Final Report - Corrections Required **Application No. ZONE-25-0021**

Record Type : Zone Change

County File: OAR2512 – Banning Lewis Ranch Village C – Review 2

City File: ZONE-25-0021

BANNING LEWIS RANCH - VILLAGE C
LAND USE PLAN
COLORADO SPRINGS, CO
COVER SHEET

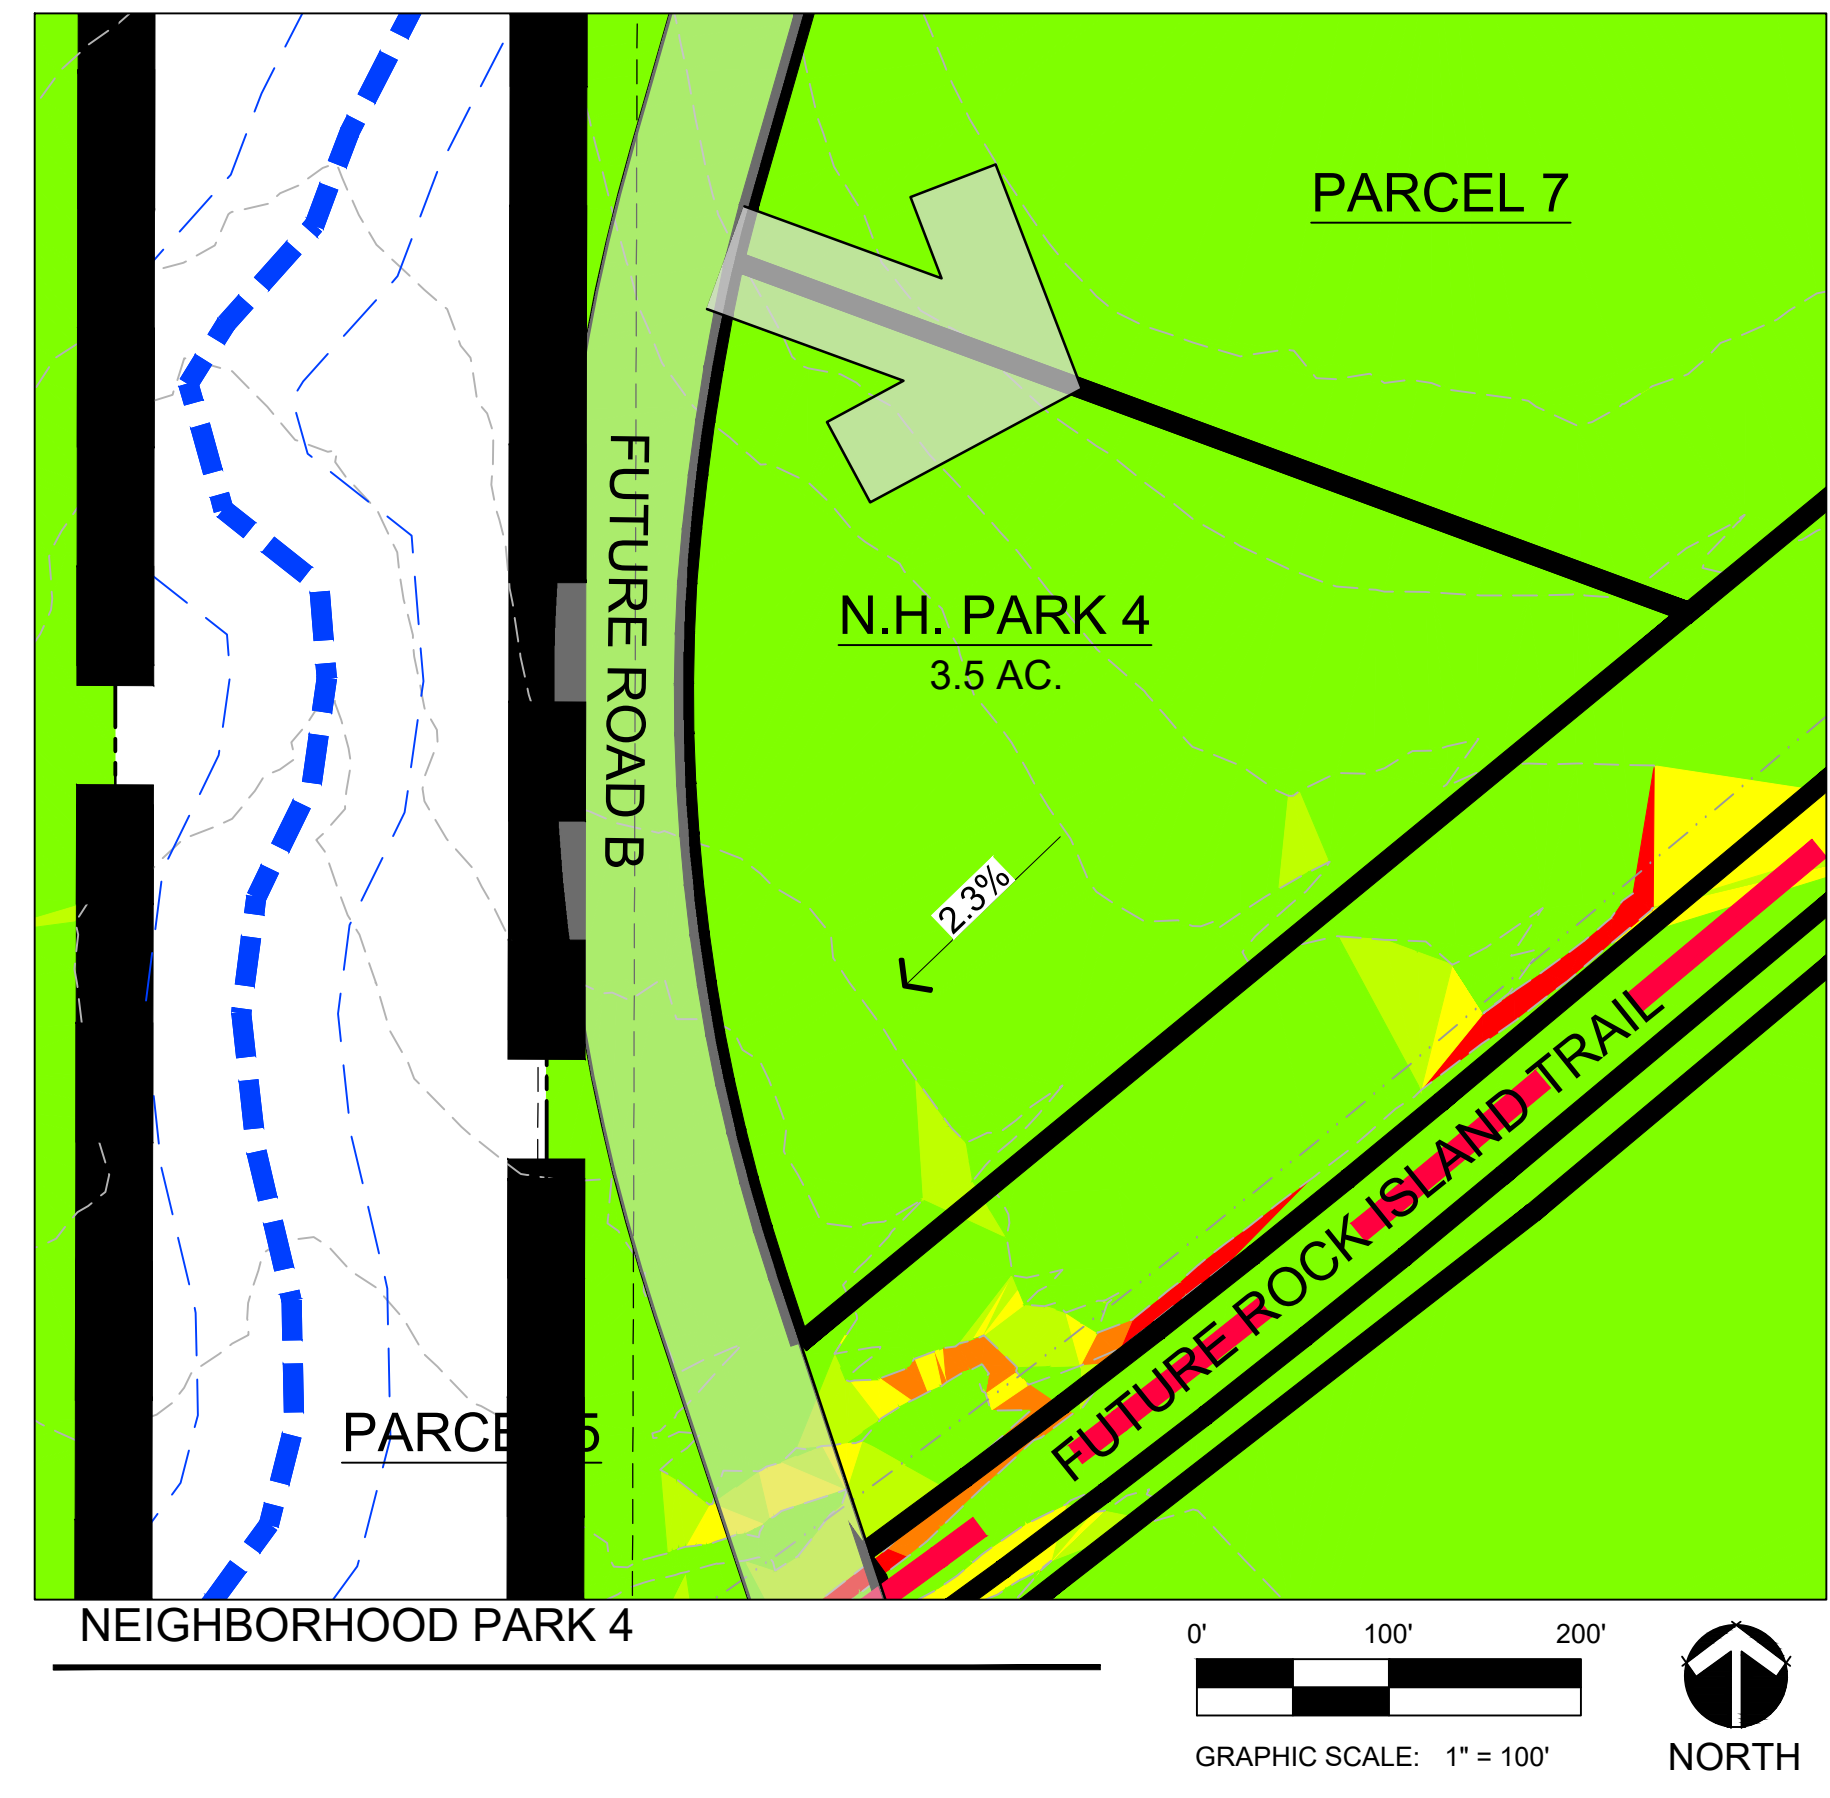
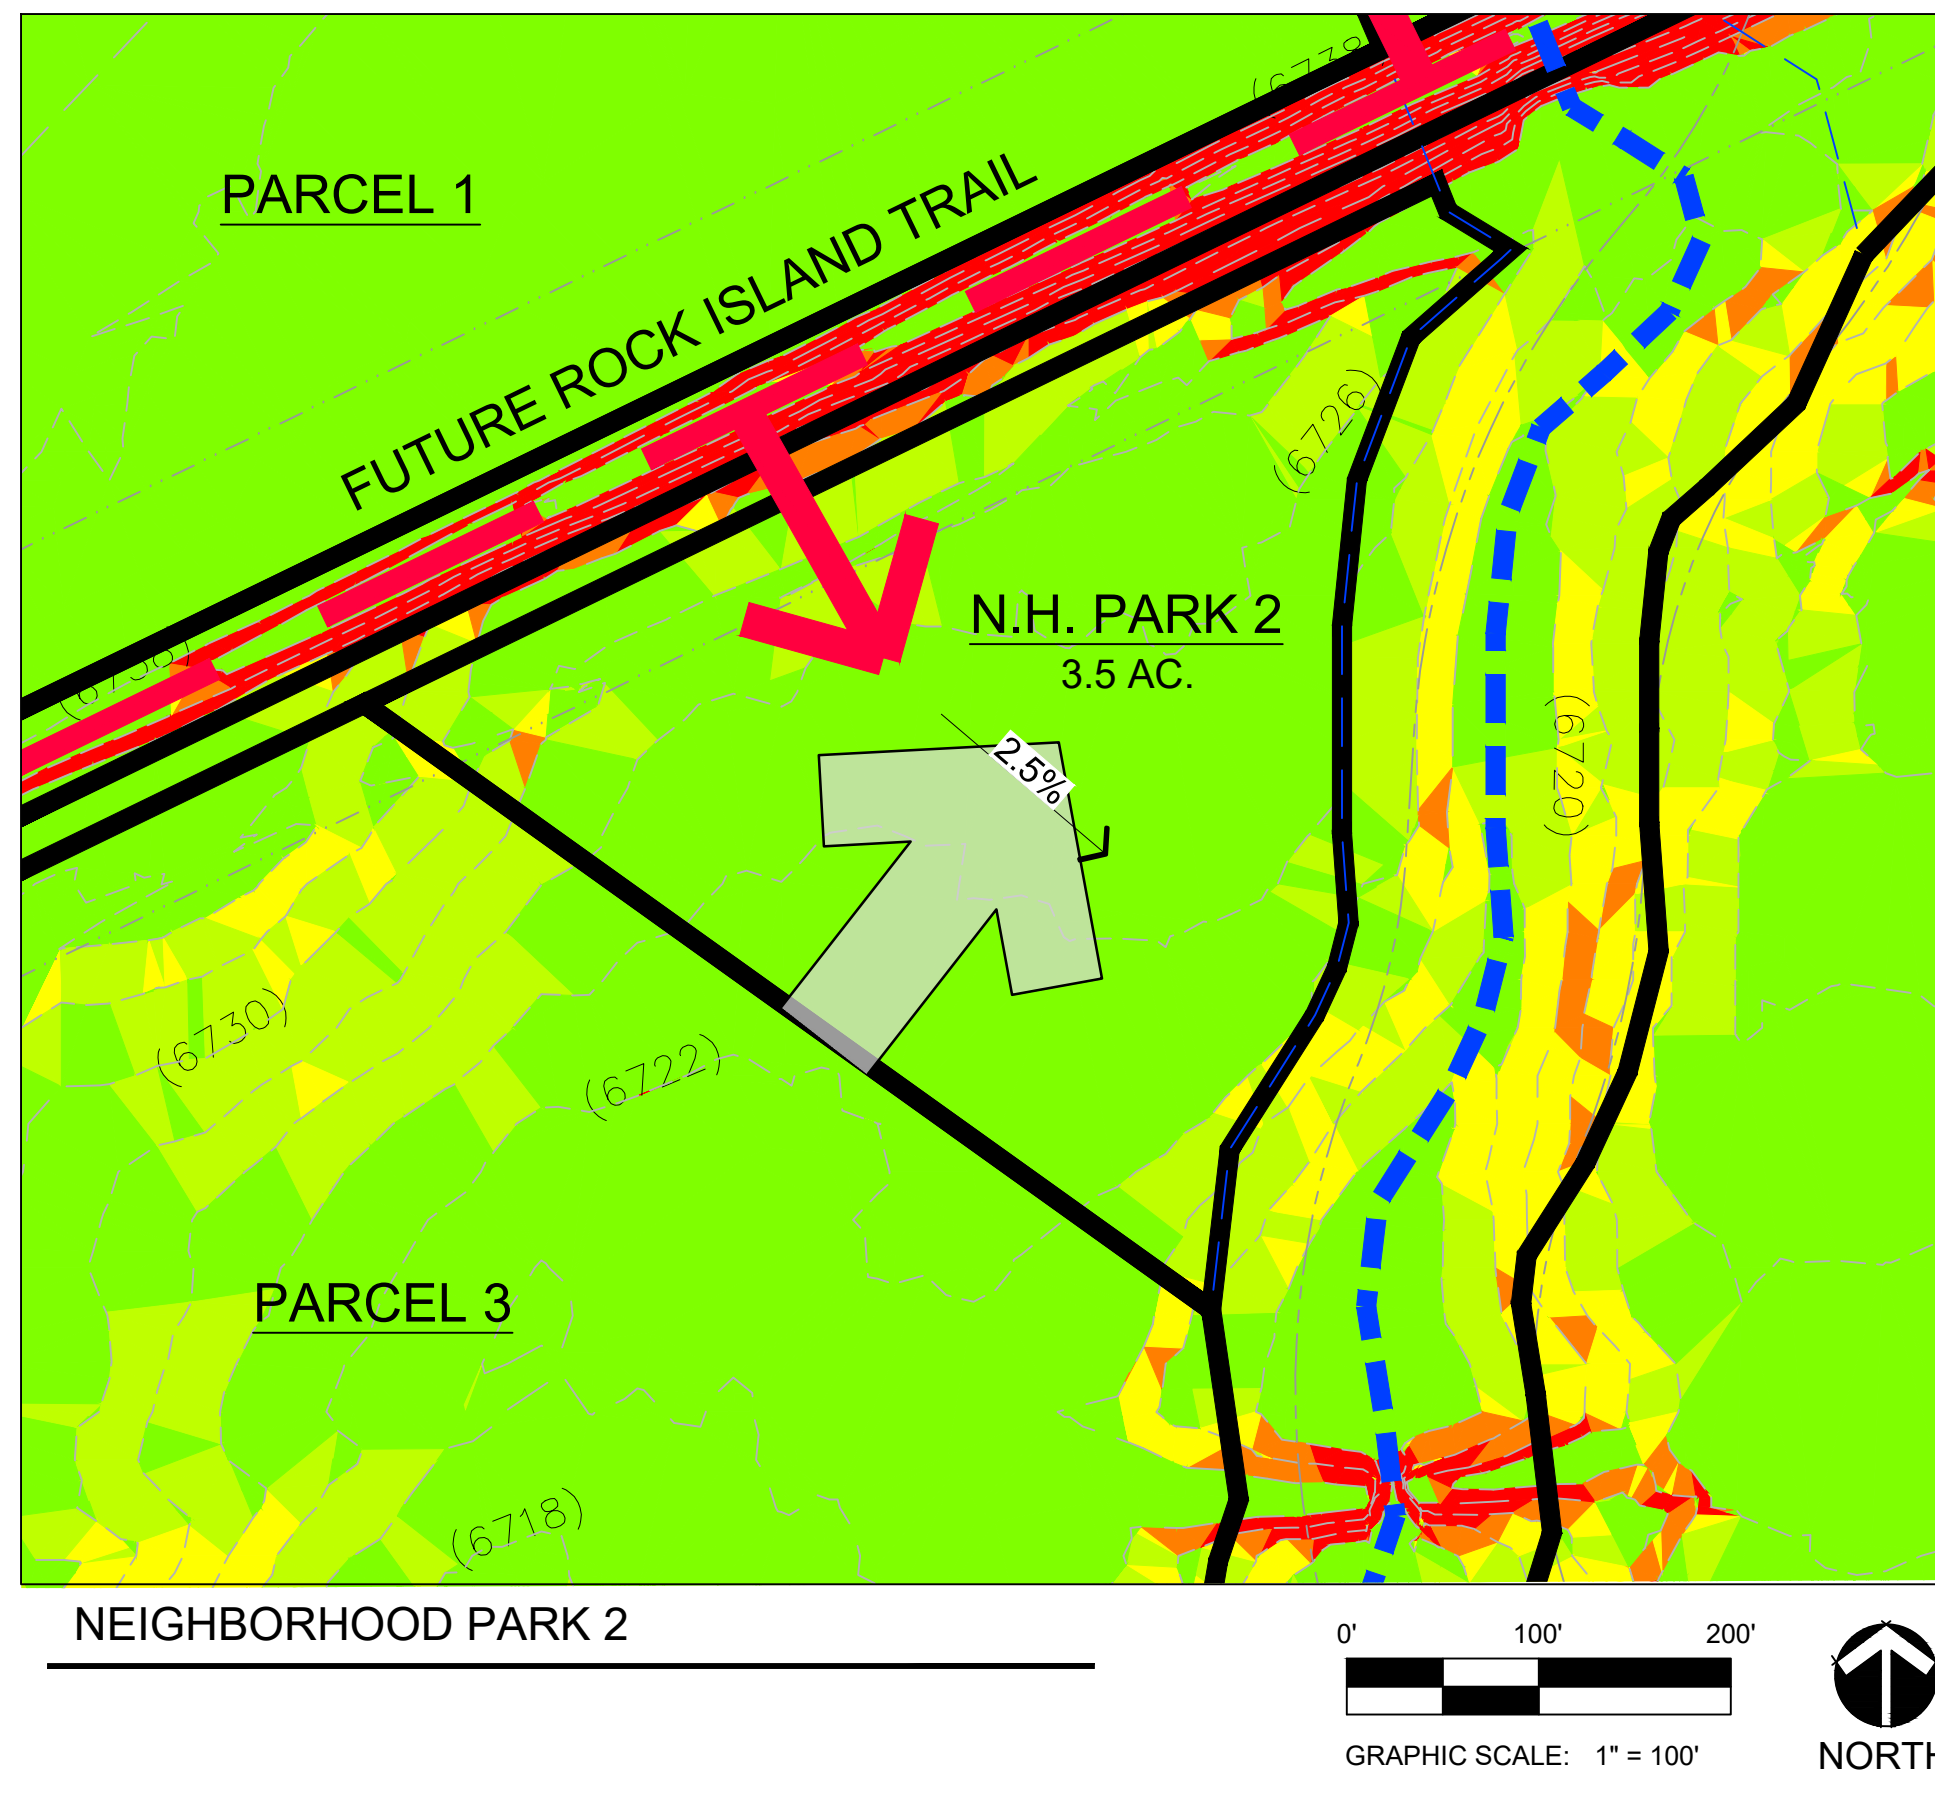
Comment ID	Reviewer : Department	Review Comments
20	Chris Padilla : COS Airport	Action Items: 8/4/2025: This action item was approved by the AAC, please provide proof of Avigation Easement. This item will be reviewed by the Airport Advisory Commison on 7/23/2025 with the below action item for Parcel # 5300000733. • Avigation Easement: An avigation easement is required or provide proof of previous recording (book/page or reception number). Add avigation easement note to plat.
